**PLANNING DEPARTMENT
DEVELOPMENT AND BUILDING SERVICES
HYDROLOGY DEVELOPMENT SECTION**

Re: Lots 7B and 8 Grande Heights Addition, Grading and Drainage Plan
Engineer's Stamp date 9-17-09 (G11/D068)

**Re: Lots 7B and 8 Grande Heights Addition, Grading and Drainage Plan
Engineer's Stamp date 12-22-09 (G11/D068)**

RE: **Lots 7A & 7B Vista Grande Addition** File: G11-D 068
Drainage Report & Plan for Platting, Grading & paving PE Stamp 11-03-08

GRADING, DRAINAGE, AND PAVING PLAN

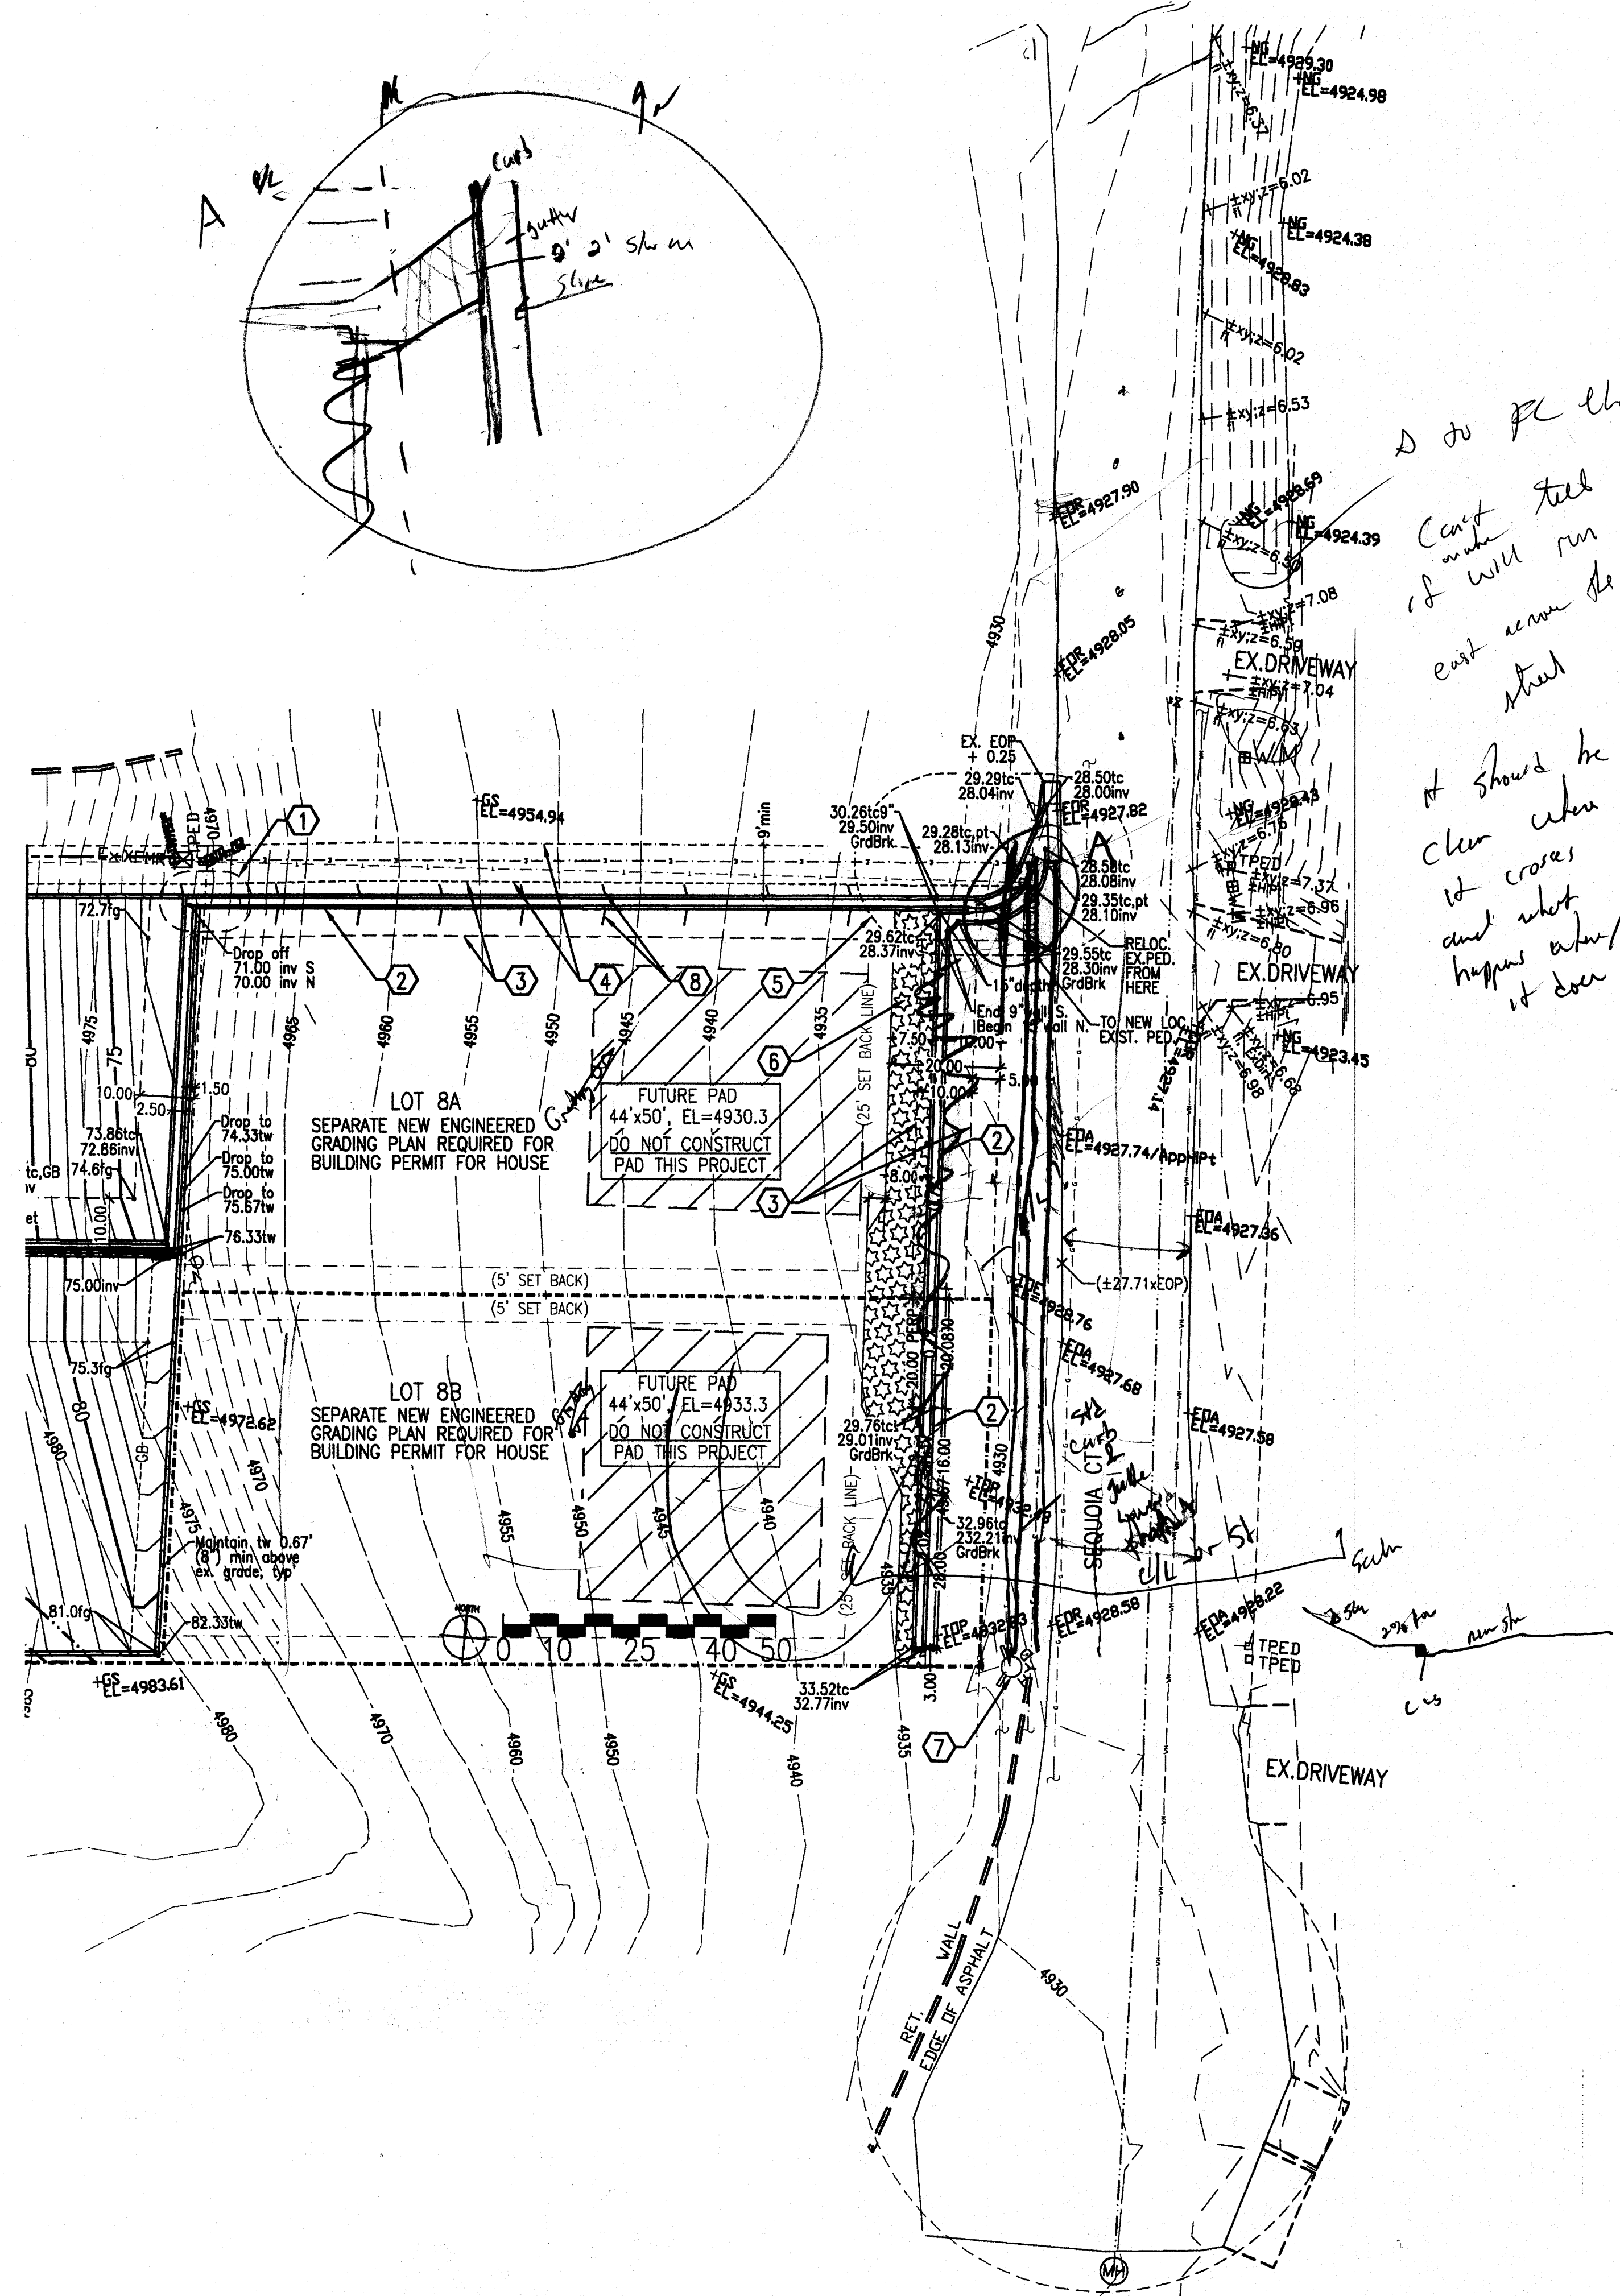
- It seems that Lot 7C could be graded to drain without storm drain.
- On Sheet C2, the note to "Maintain wall 0.67' above existing grade" should be changed to "Maintain wall to 0.67 feet above new grade" to prevent runoff from running over the wall.

- The Note on Sheet C2 stating to maintain the tw 0.67 min above ex. grade should state to maintain the tw 0.67 min above new grade.

- What is to prevent sediment from entering the north-south channel on Lot 7D?
- Detail B5 depicts the rundown is 19 inches high, yet there is about 7 feet of grade difference. It would also be beneficial to show the entire construction of this rundown in one detail rather than referencing Detail I/C5.
- Detail G/C5 specifies that the north-south channel is per Detail E/C5, while Sheet C2 specifies Detail D/C5 for the same channel.

FILE NAME: C:\pvt\Ward\Ward08.dwg; LAYOUT TAB: C3-LB;
IMAGES: C:\pvt\Ward\Ward08\c3\c3276.png; ...g-11.tif; ...Monarc-Ward-XLS.TIF; ...Ward-WARD08-XLS.TIF; ...Ward02-XLS.TIF
XREFS: None
REVISIONS:

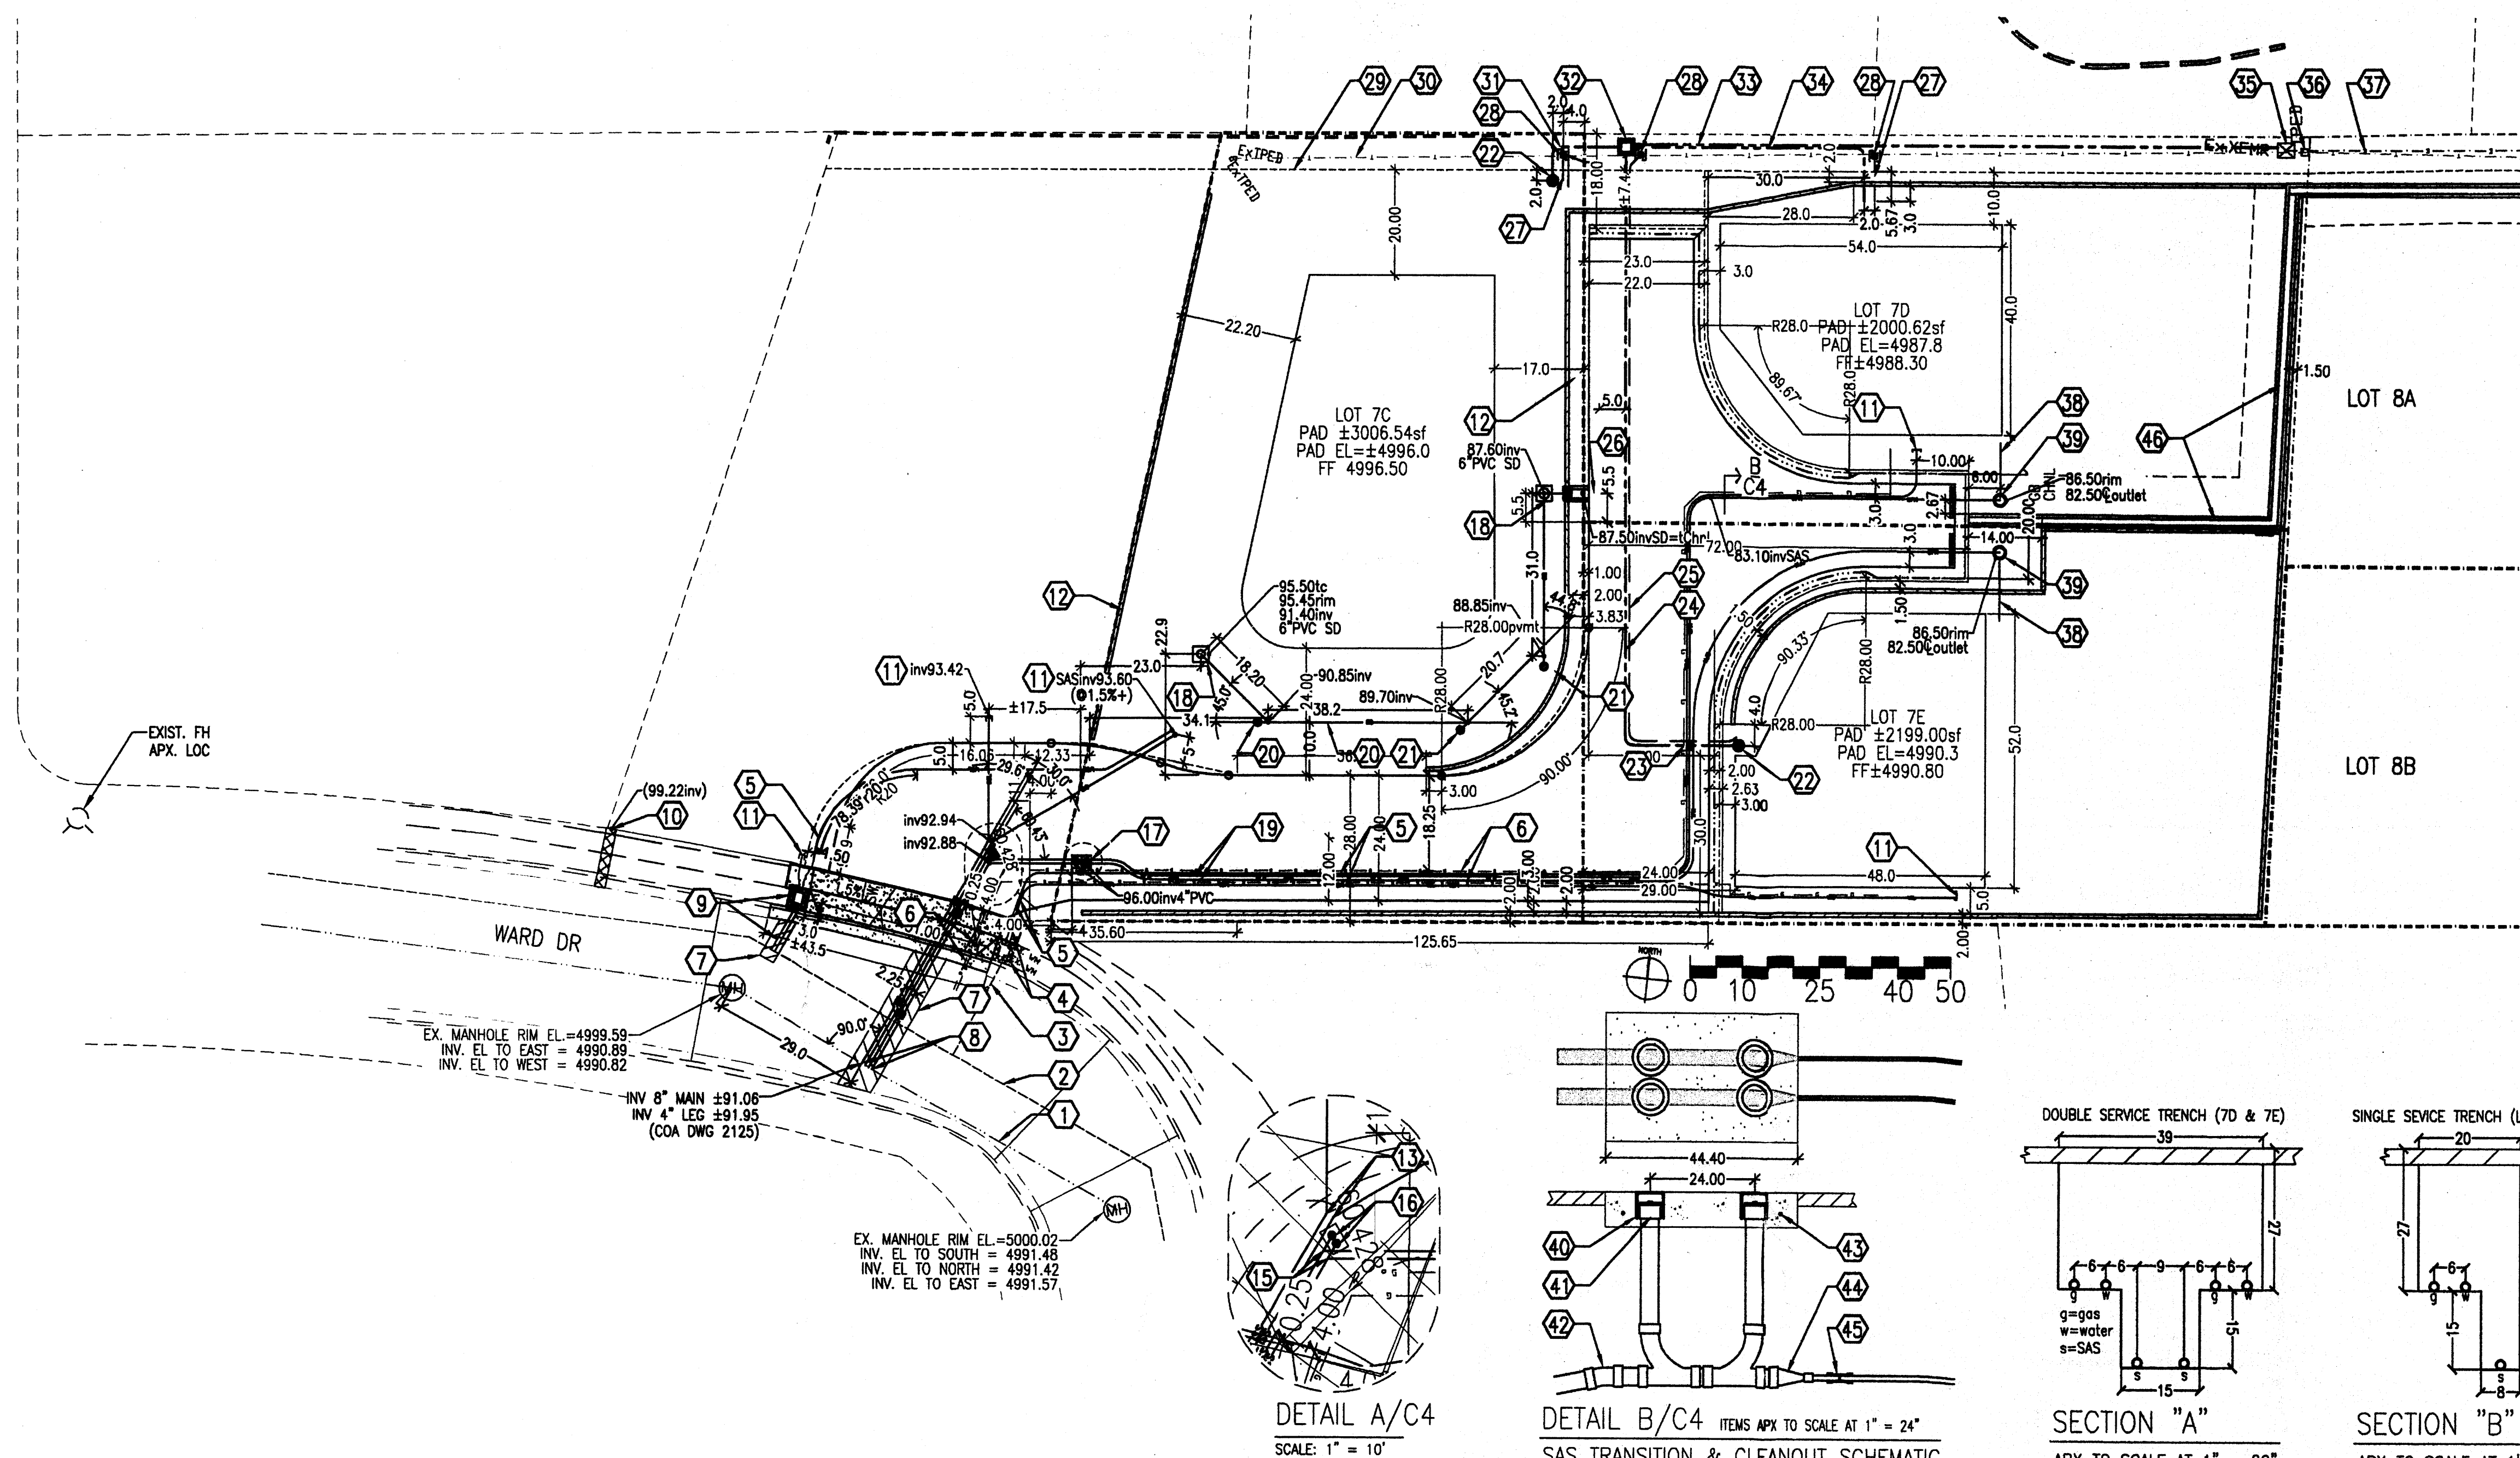
- Rather than stating the slope is greater than 20% (Sheet 7), provide the approximate/average slope.
- The soil underneath the channels should be compacted.
- Provide a scale on Sheet C3.
- On Detail G/D5 one of the channels is referenced incorrectly (E5 rather than D5).
